Subject: Planning of houses in Emley

Outline application for erection
of residential development(2020/91215)

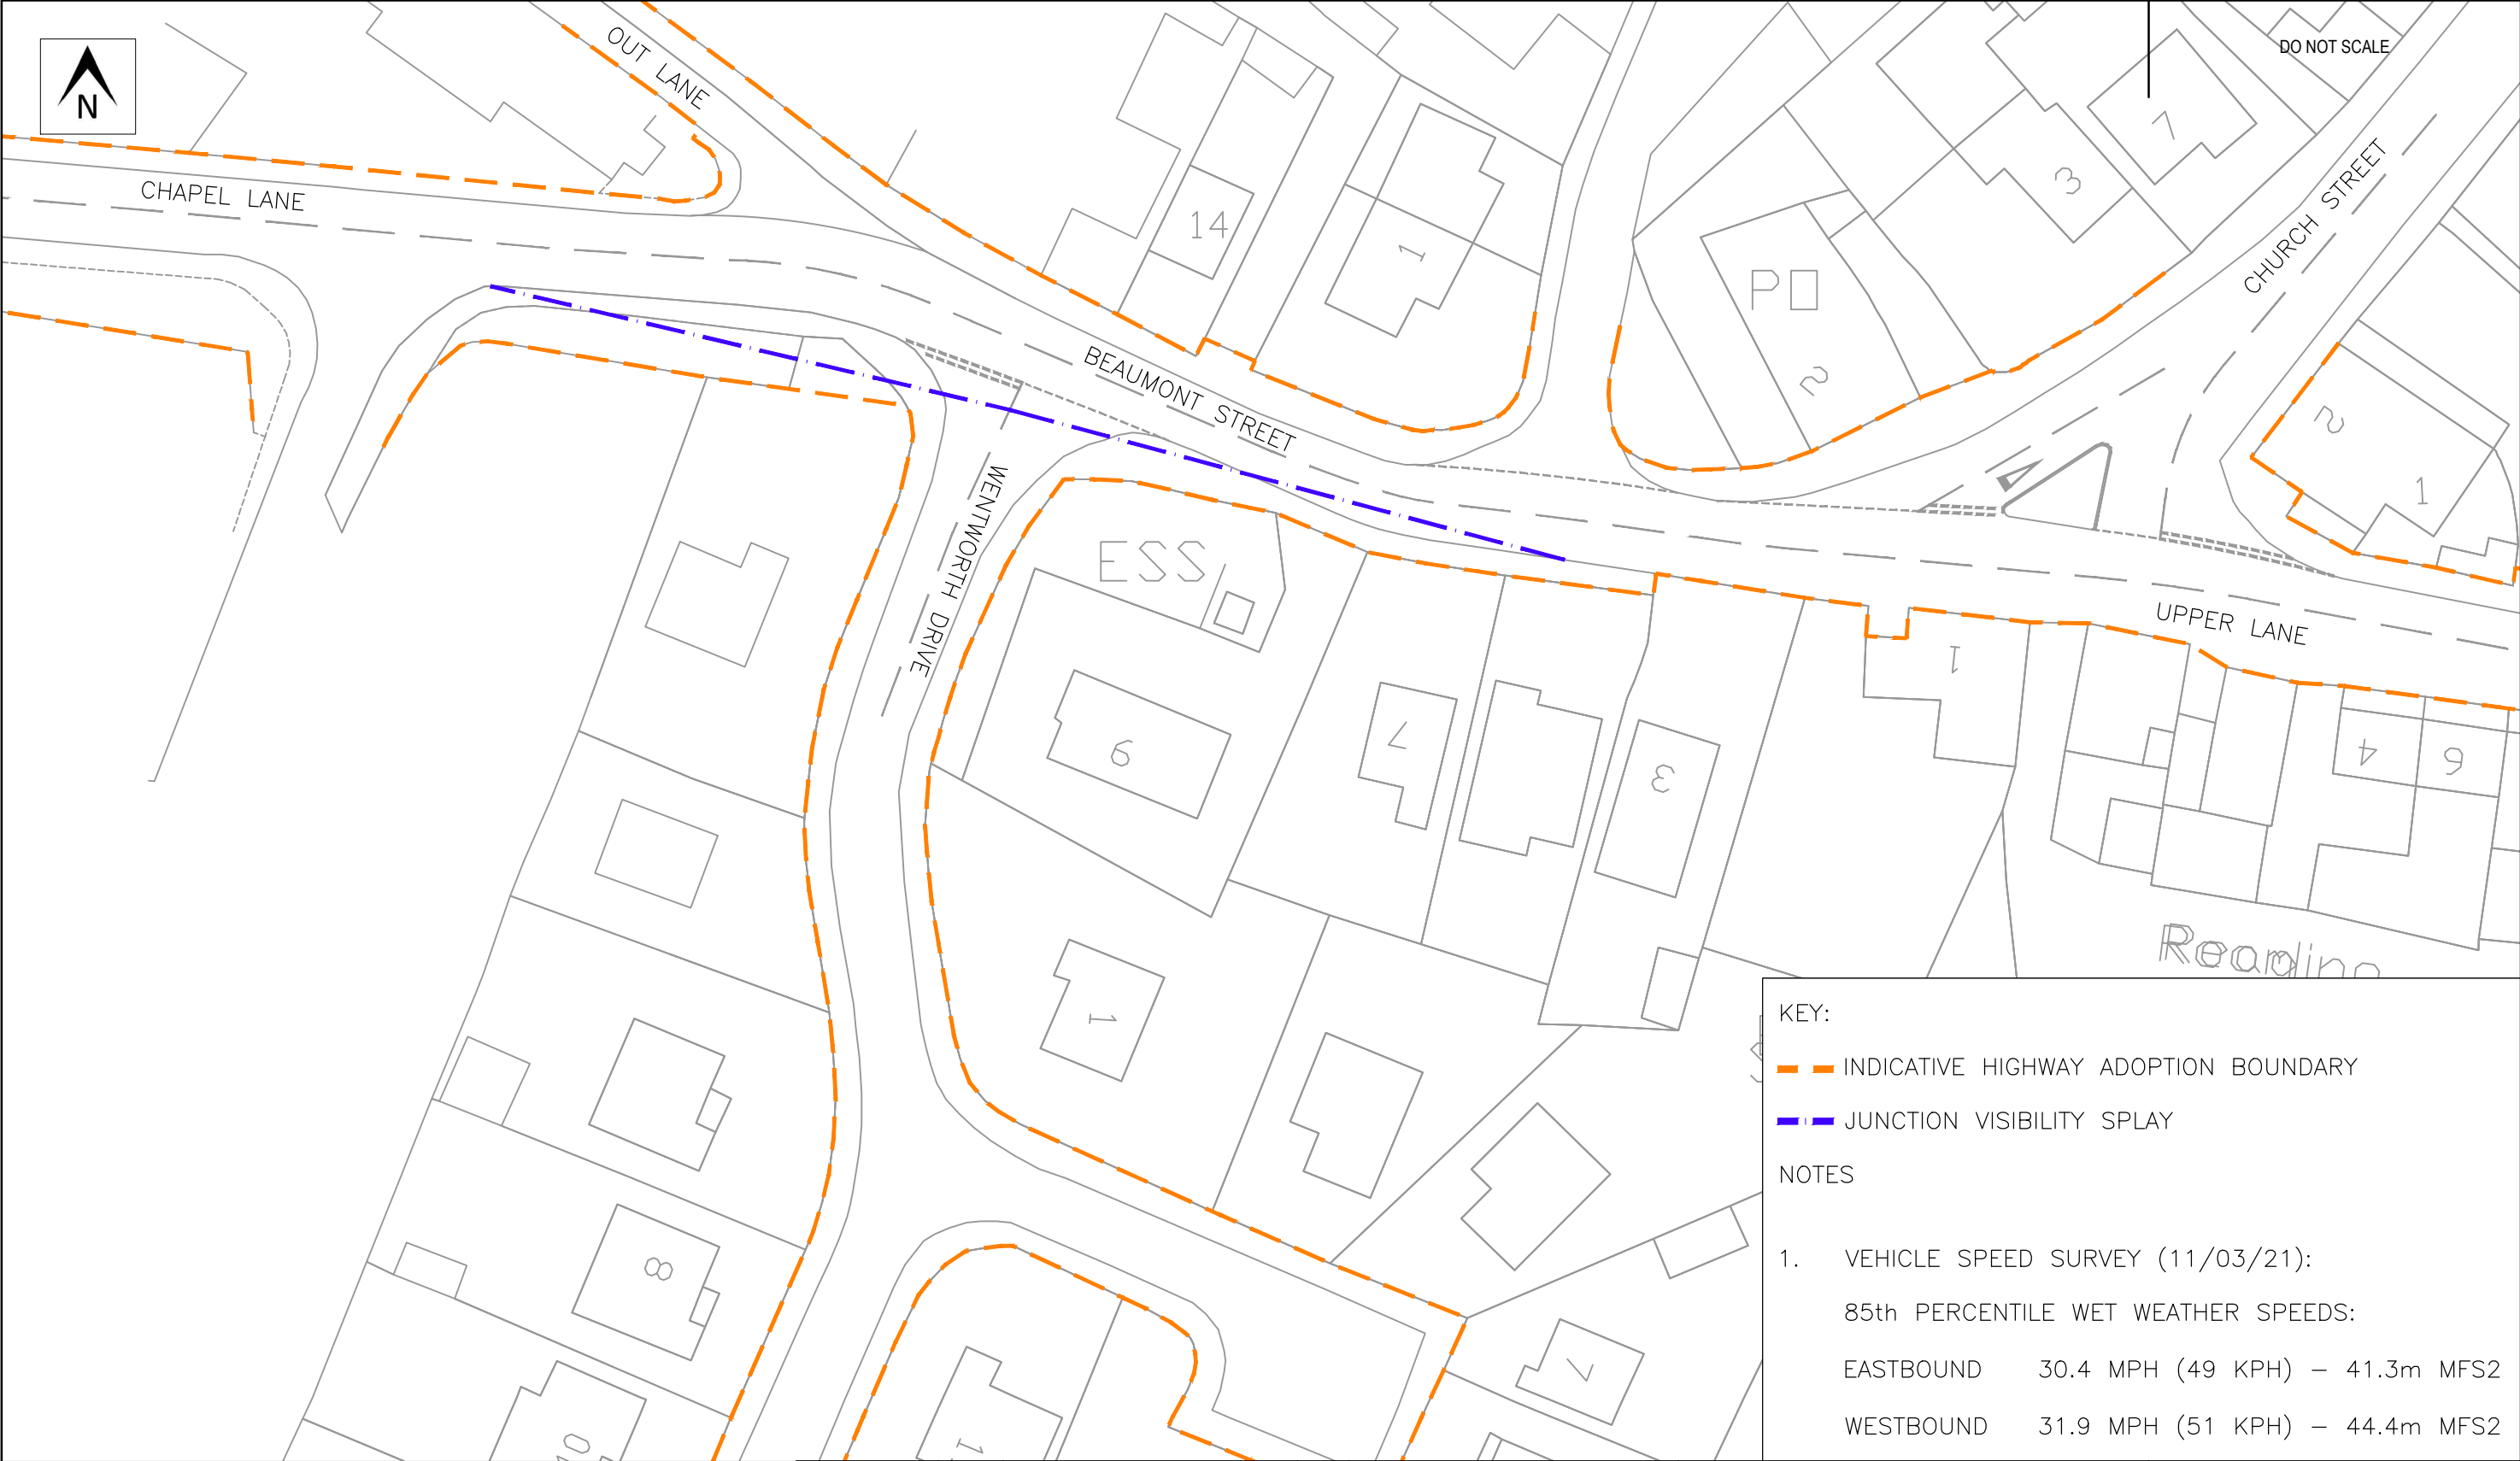
The proposed site is suggesting access from Wentworth Drive. The entrance to Wentworth Drive/Avenue is from Beaumont Street which is a continuation of Upper Lane. There is a lack of parking on Beaumont Street therefore cars parked at the junction of Beaumont Street, and Wentworth Drive cause major problems for traffic entering and leaving the existing estate. This is exacerbated in Winter when there is snow and ice as the vehicles that usually park on Outlane park on and around the junction of Wentworth Drive making it dangerous when coming into and out of Wentworth Drive.

The bus stop has been re-sited and is now near the corner of Wentworth Drive/Beaumont Street where passengers queue on the pavement thus making visibility for oncoming traffic very difficult when exiting Wentworth Drive. The public and school children have to stand next to the busy main road at some of the busiest times of the day while waiting for the bus.

Traffic travelling from the Emley Moor approach over a blind rise and often must manoeuvre into the entrance of Wentworth Drive to avoid the traffic coming out of Outlane. Traffic travelling out of the village have to cross into the entrance to Wentworth Drive to avoid the oncoming traffic and to avoid the parked cars on Beaumont Street. The whole junction is a bottleneck. Traffic includes single/double decker service buses and school buses, HGV's, delivery vans which have increased recently, commuter traffic heading for the motorway network, and because this is a farming community many large agricultural vehicles. This is a very hazardous junction! The traffic survey done in 2020 was carried out during the first national lockdown and was not a true reflection of the traffic travelling through Emley.
